From: Laura Gibbons
Sent: 05 September 2019 10:37
To: Planning.Responses <Planning.Responses@arun.gov.uk>
Cc: Andrew Wood <Andrew.Wood@arun.gov.uk>
Subject: RE: Planning Consultation on A/113/19/DOC

Engineers Comments Regarding Condition 9- surface water drainage design

APPLICATION NO: A/113/19/DOC

Site Address: Crete Nursery Dappers Lane Angmering BN16 4EN

- KEY:
- Existing Ground Level
 - Proposed Ground Level
 - Surface Course
 - Binder Course
 - Base
 - Sub-base
 - Capping
 - Topsoil
 - Filter Drain

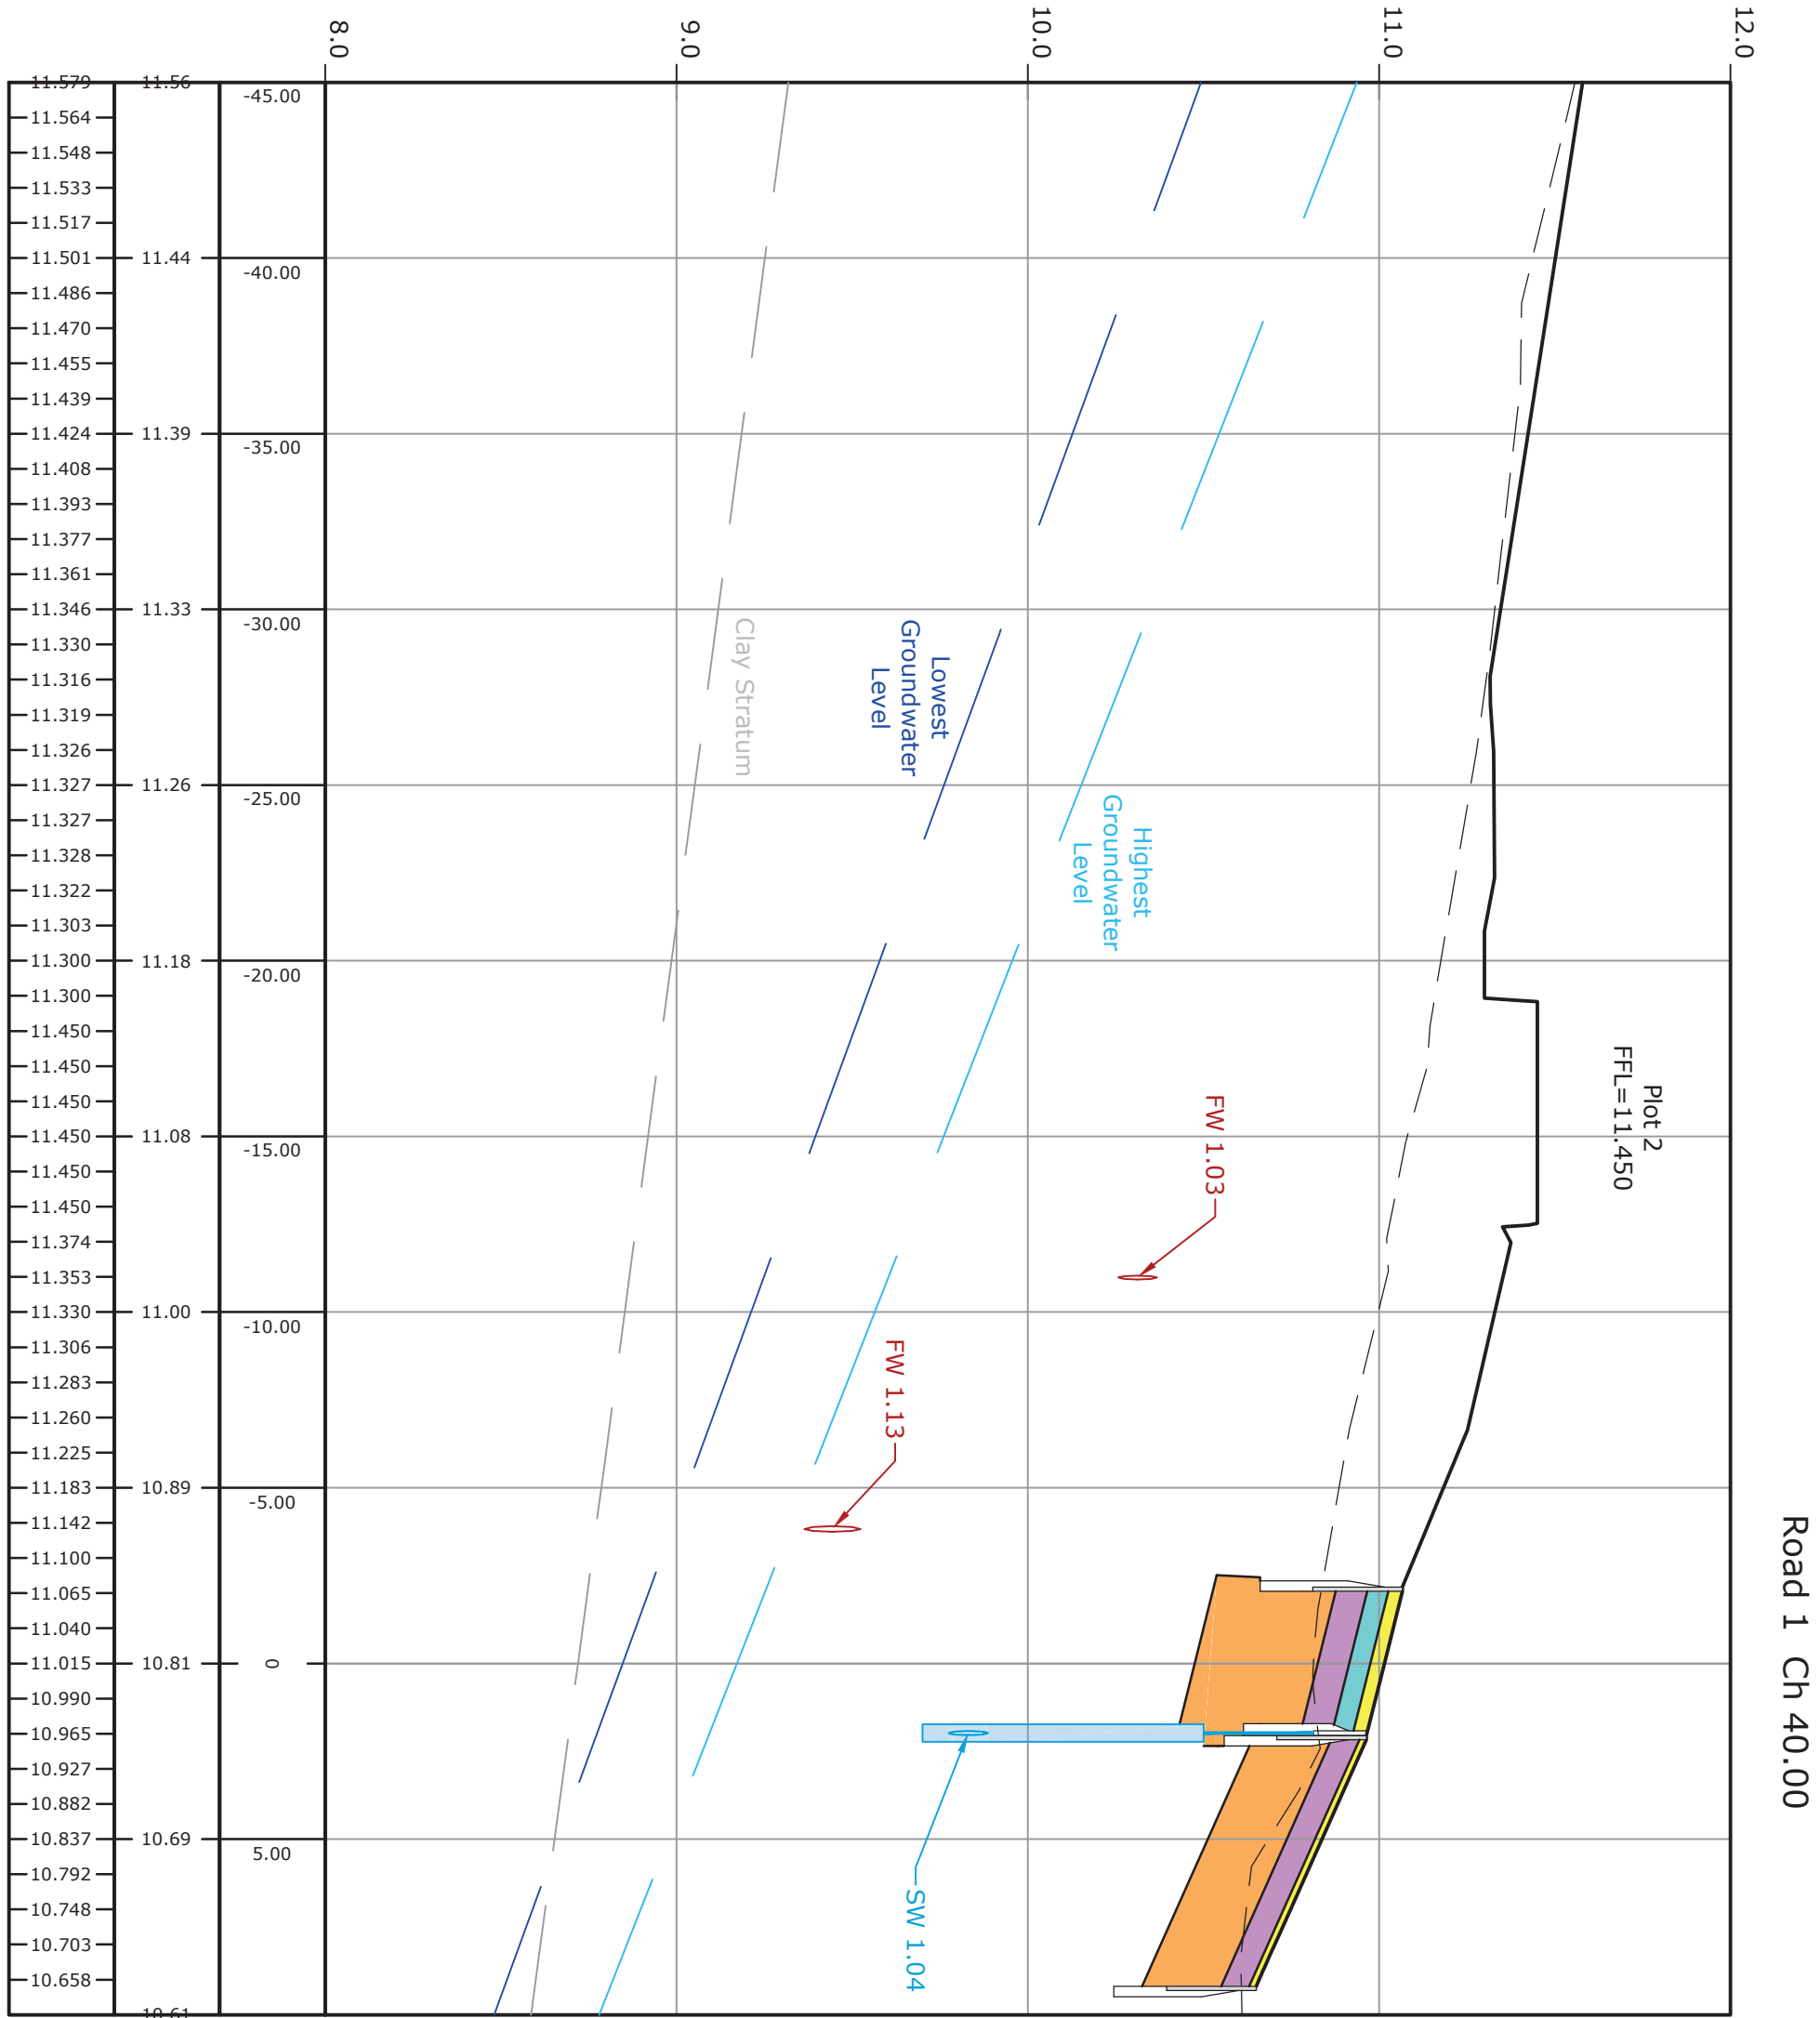
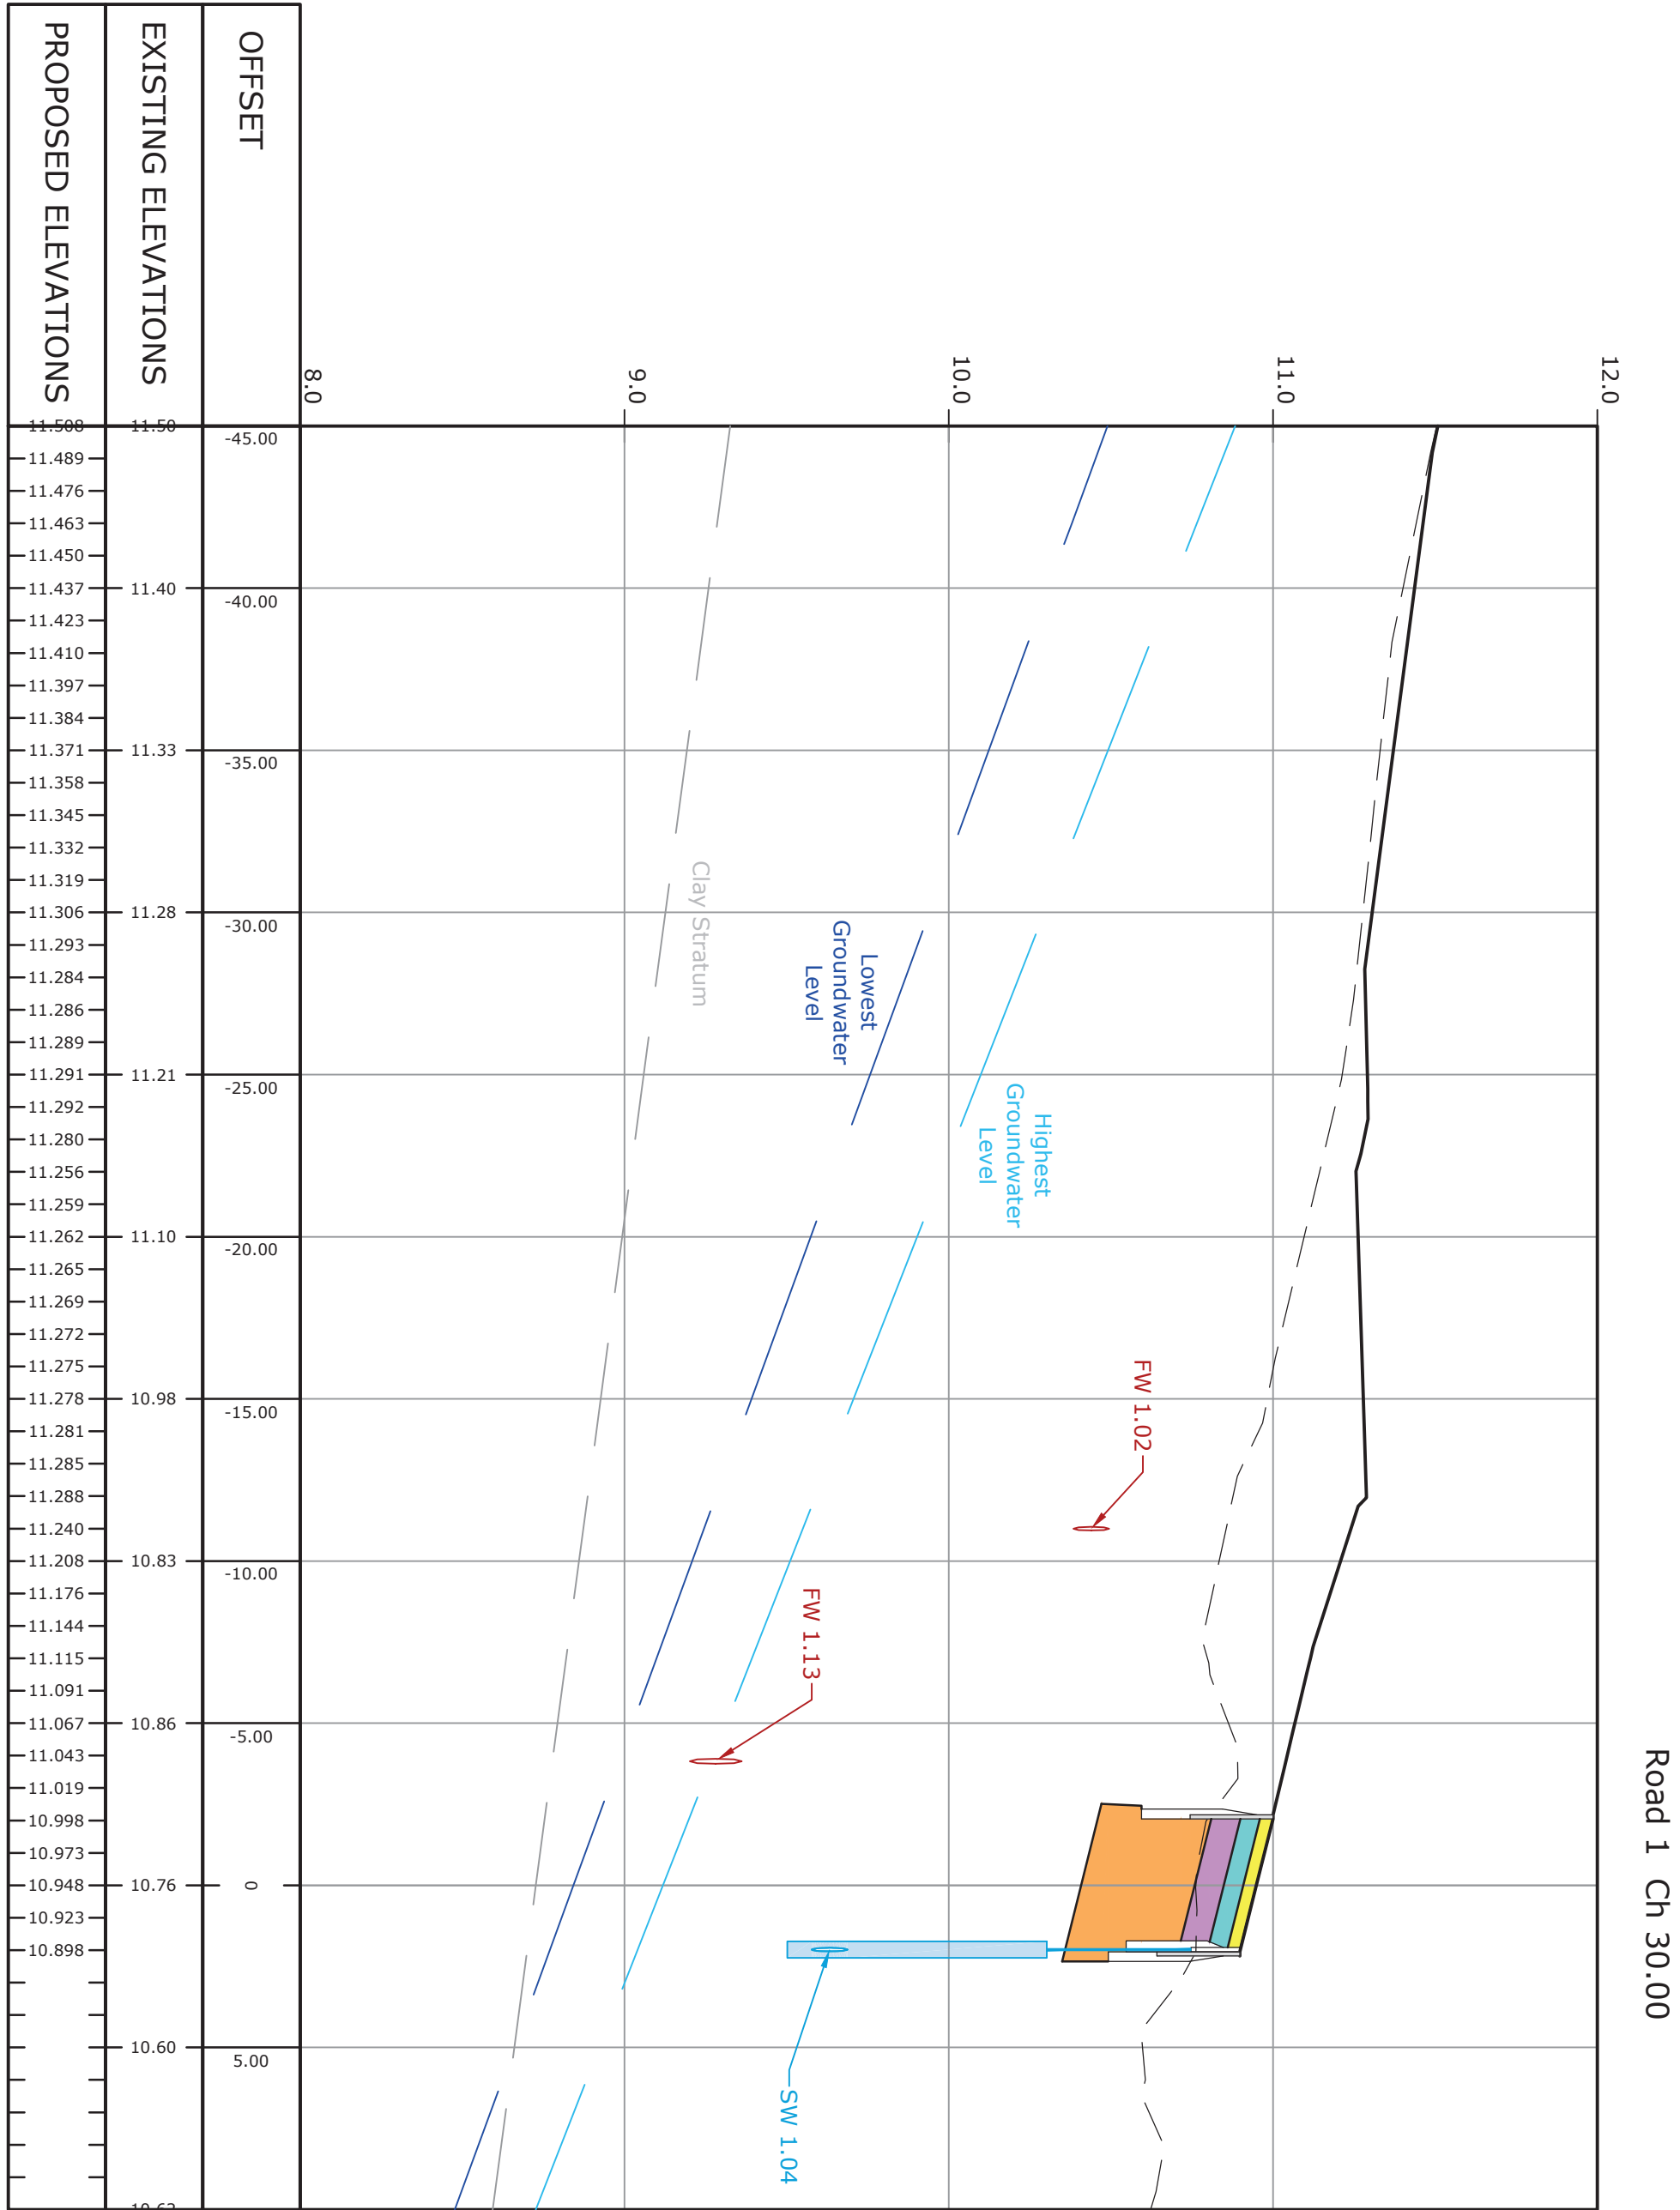
5. From looking at cross sections it also appears that the filter drain will be on a slope, please ensure this is accurately depicted within calculations.
